About the application

Application number: 2025/92993	
What is the application for?:	Erection of detached dwelling with integral garage
Address of the site or building:	rear of, 9, Riley Lane, Kirkburton, Huddersfield, HD8 0RZ
Postcode:	HD8 0RZ

User comments

DRAWING TITLE  
**PROPOSED SITE SECTIONS**

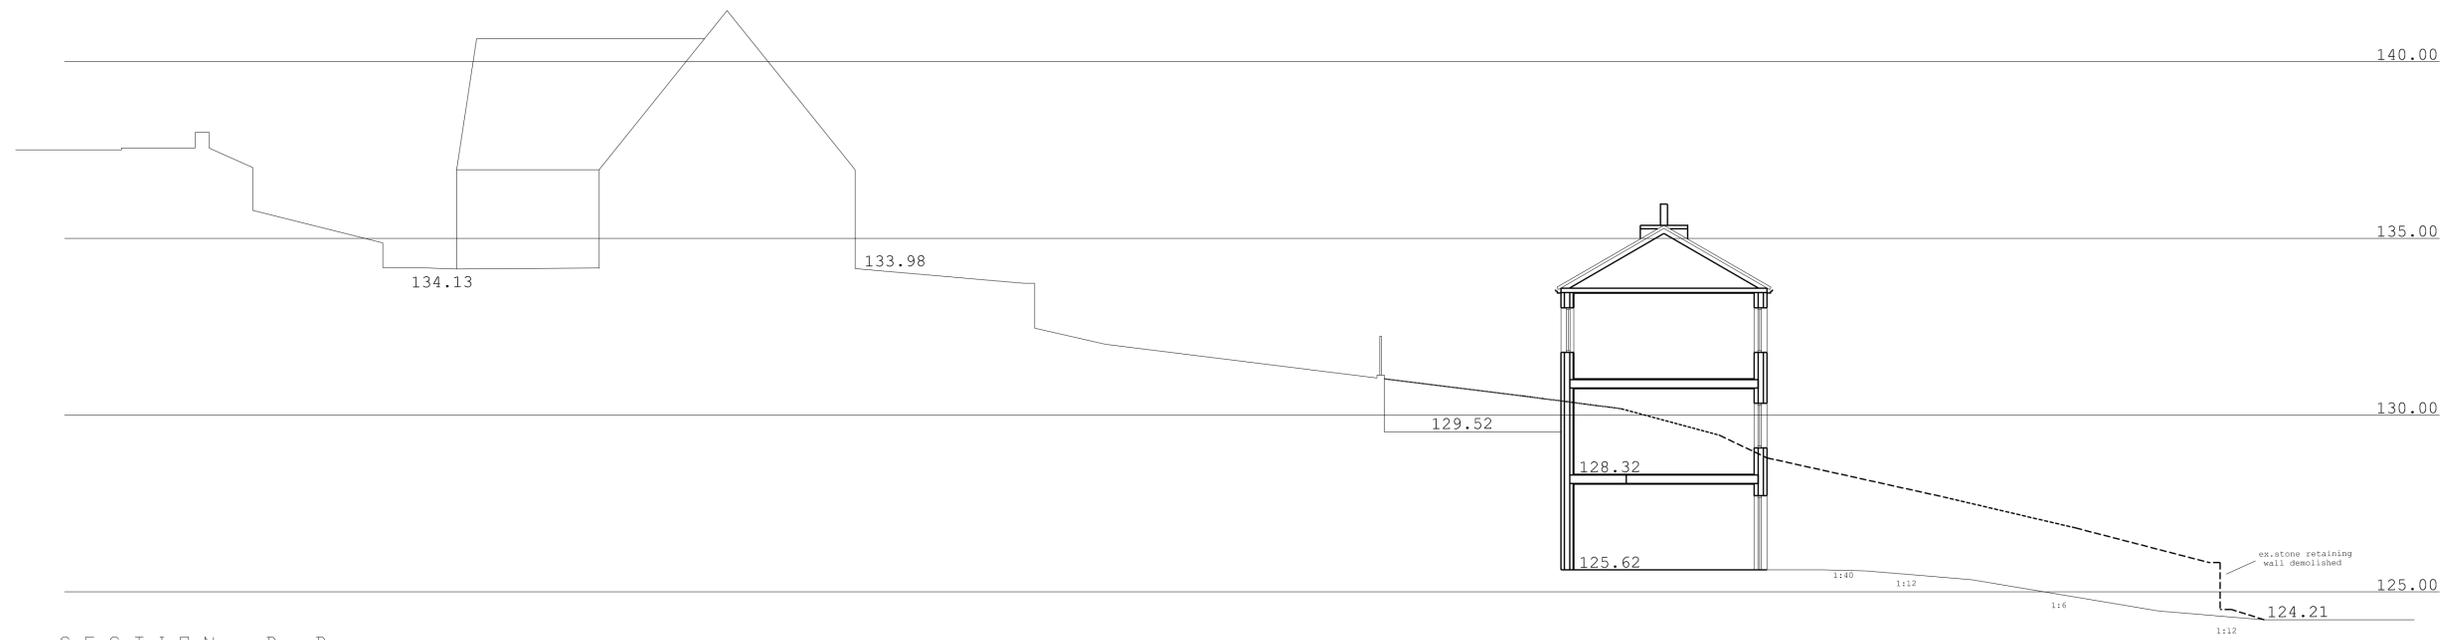
Type of comment: An objection	
Do you wish your comments to be published on the website anonymously?	Yes
<p>It appears that since the previous successful application, the planned position of the property has been moved forward thereby causing considerable loss of light, due to immediate and permanent obstruction at a distance of less than 5 metres, directly in front of the kitchen and dining room windows of No.7a Riley Lane.</p> <p>This was discussed with the previous planning officer involved at the time and it was agreed to move the property back so as not to cause any disruption to the light enjoyed by the afore-mentioned rooms.</p> <p>Please amend the plans so they mirror those of the previous application. Thank you.</p>
